**Consultation Response from KC,
Conservation & Design**

2025/92020 2, Mount, Edgerton Road, Edgerton, Huddersfield, HD3 3AE

**Change of use and internal alterations to dwelling (C3) to form supported living
accommodation (C2) (Listed Building within a Conservation Area)**

Date Responded:8/10/25

PROPOSED GROUND FLOOR PLAN

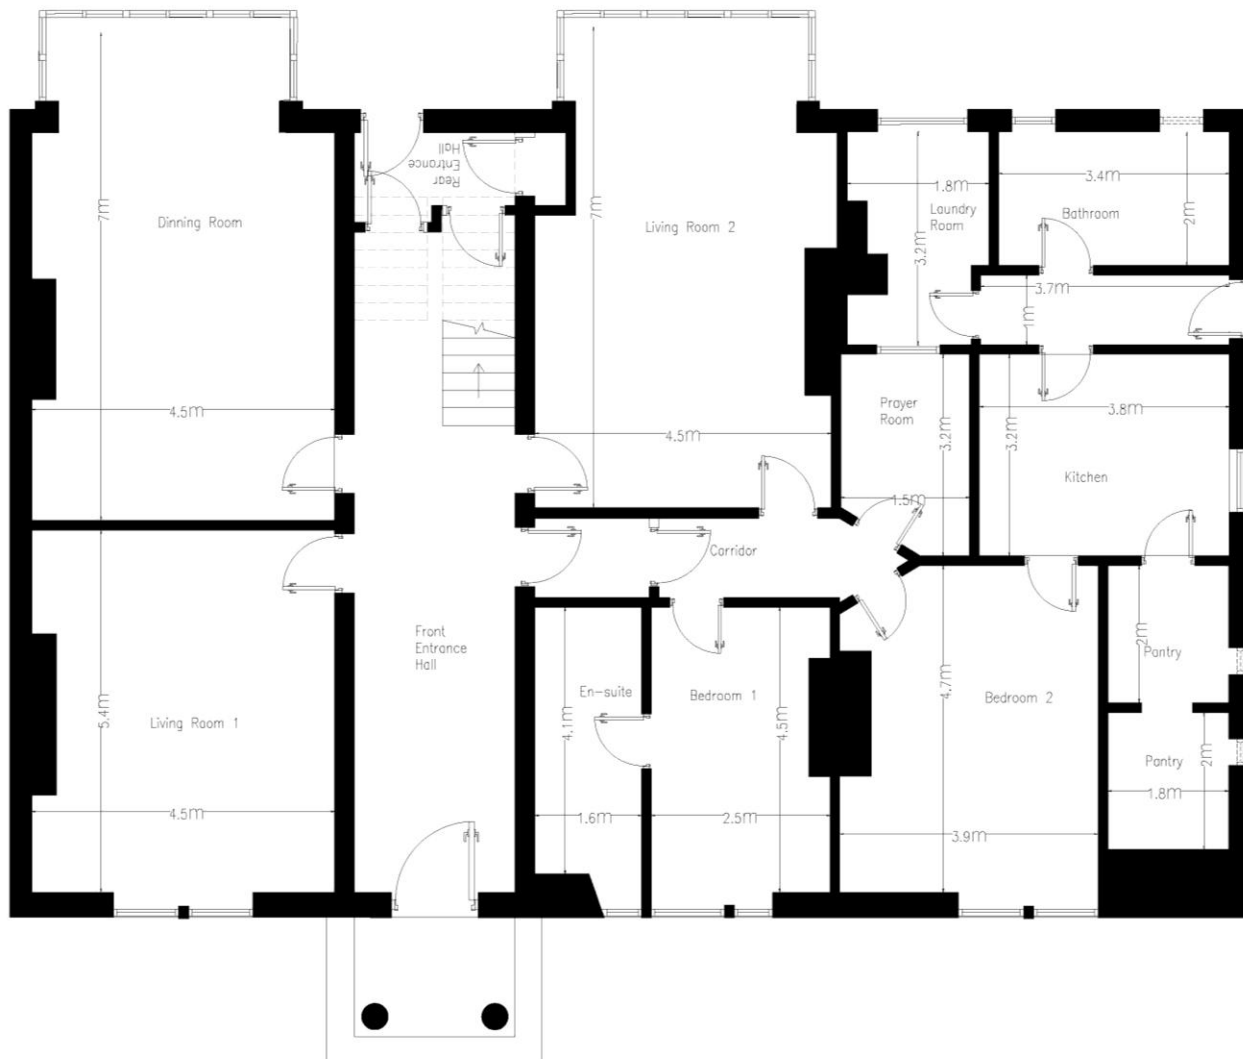
Ground floor – 2 new ensembles to rooms at the rear.

Regarding the pantry – if it's possible to retain any original cupboard or shelving features to be used in the new utility room on the ground floor, that would be welcomed.

PROPOSED FIRST FLOOR PLAN

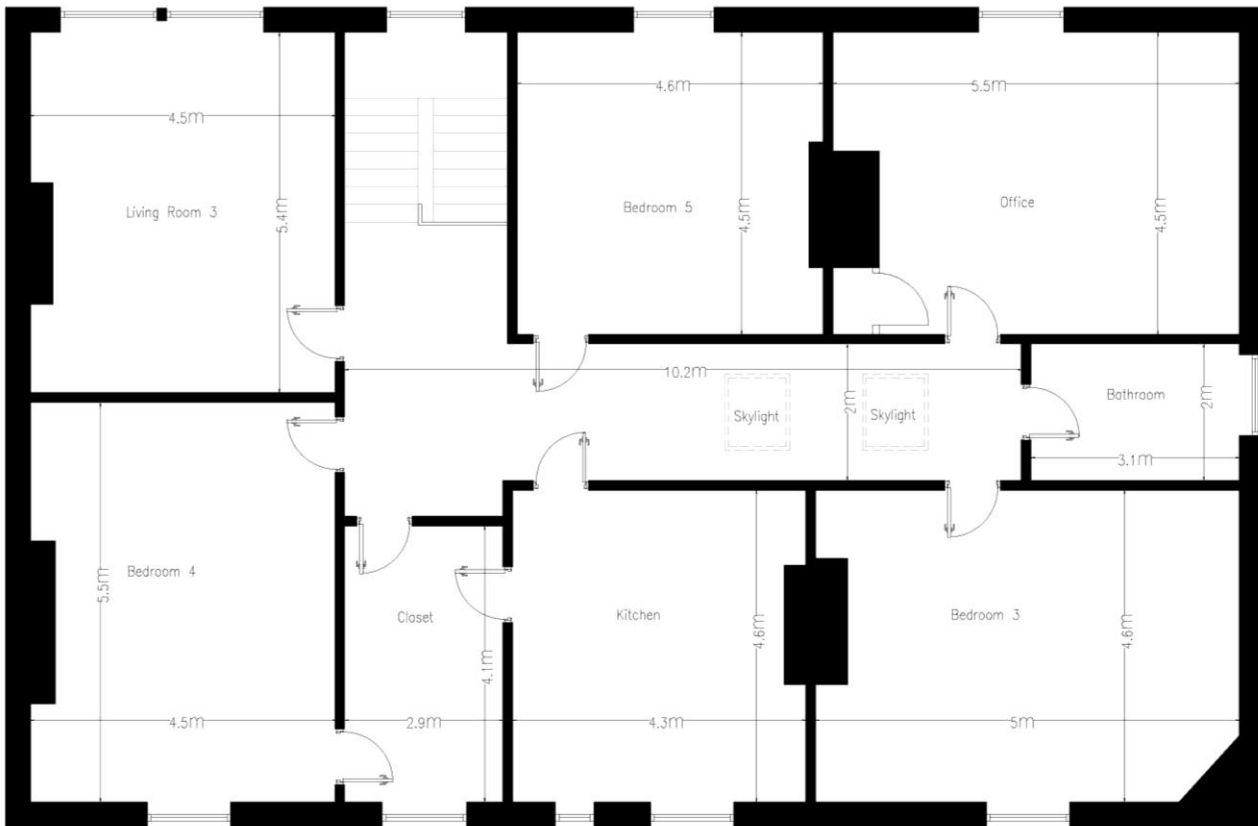
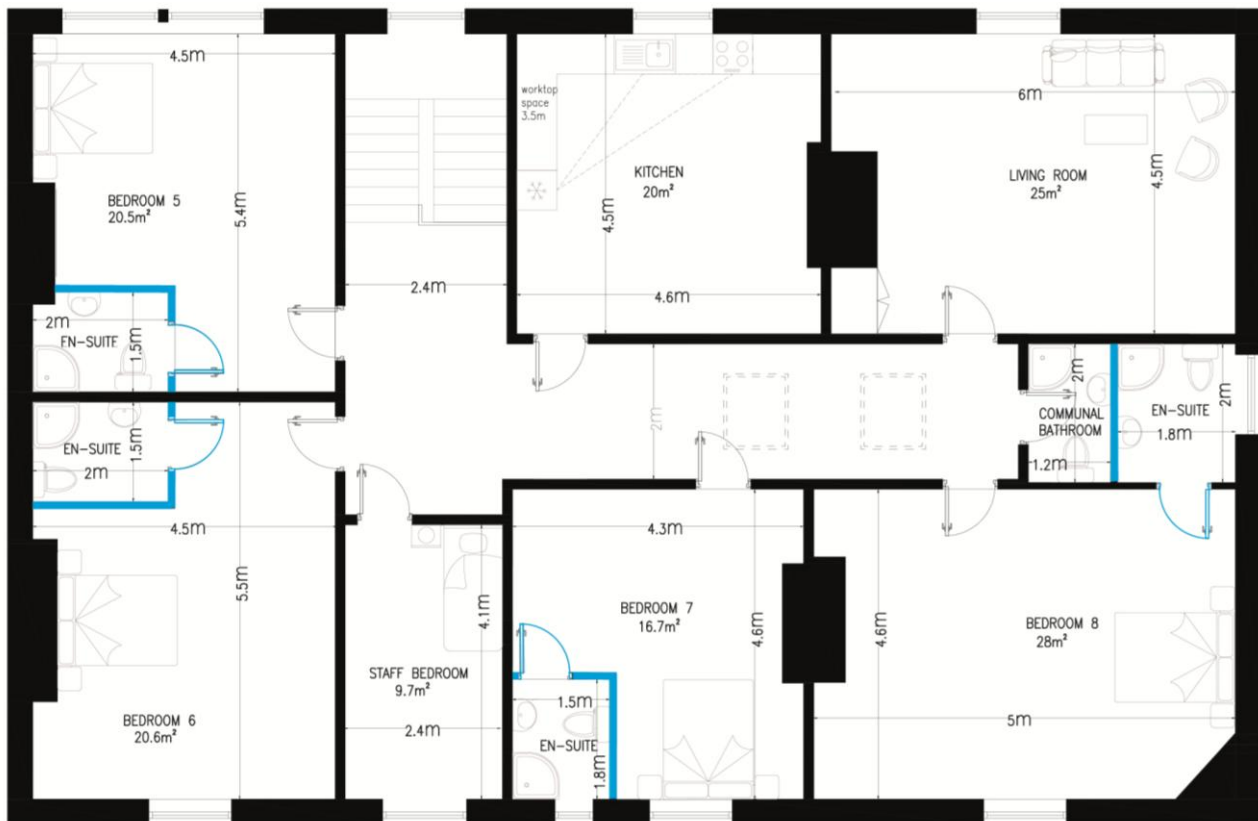
First floor – ensuite to bedroom 7 has a small existing window at the front. I note there is already a sump close to the small window, if this can be utilised for the new bathroom, rather than introducing new pipework, it would be preferred.

- 2 other ensembles adjacent but not removing fireplaces.
